Consultation Response from KC,
Lead Local Flood Authority

2024/92519 Victoria Tower, Lumb Lane, Castle Hill, Almondbury, Huddersfield, HD4 6TA

Discharge of details reserved by conditions 3 (Construction (Environmental) Management Plan), 8 (access road works), 18 (kitchen waste water), 20 (archaeological investigation), 29 (biodiversity) and 30 (public right of way) of previous permission 2018/93591 for erection of restaurant/café/bar, six guest rooms, exhibition/interpretation room, WCs, terrace, car parking and ancillary accommodation

Discharge of Drainage Conditions

Fig 1 - Typical installation of KGB Grease Interceptor

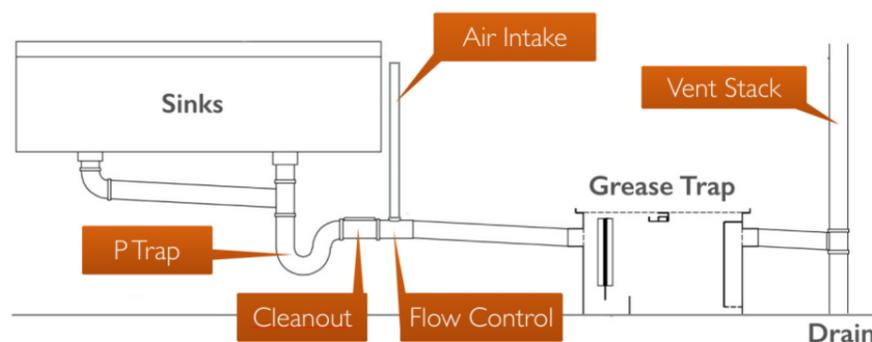
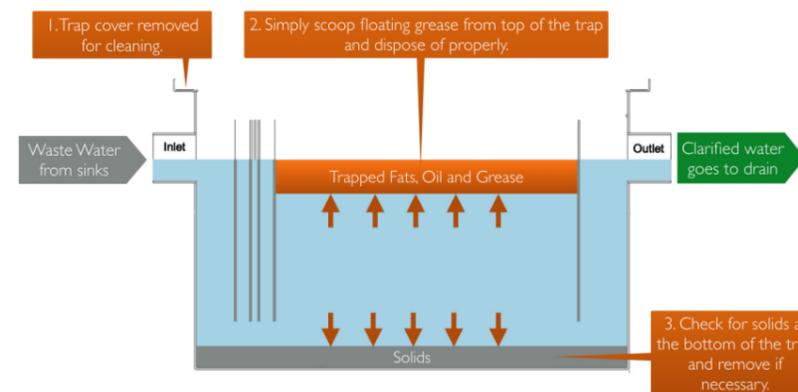
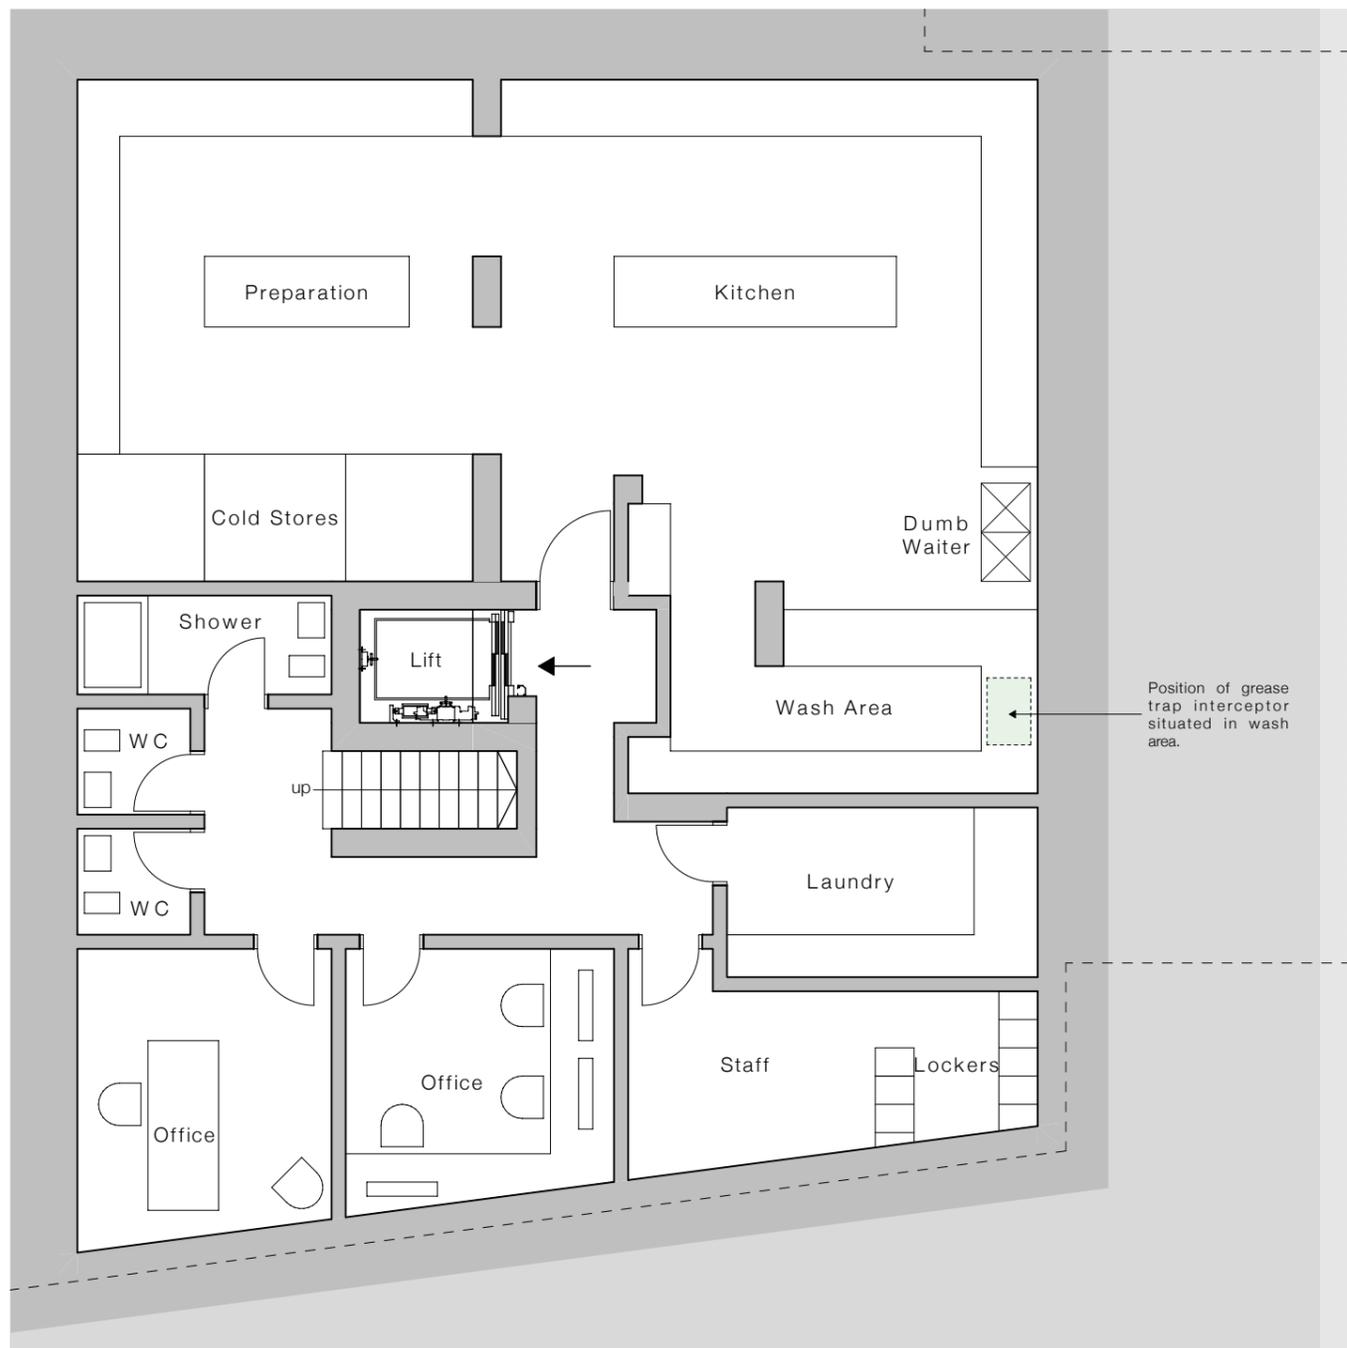
- 3287 (SK) 110, Grease Trap Details

The LLFA confirms that the details of the grease trap are acceptable.

Therefore Condition 18 **can be** discharged.
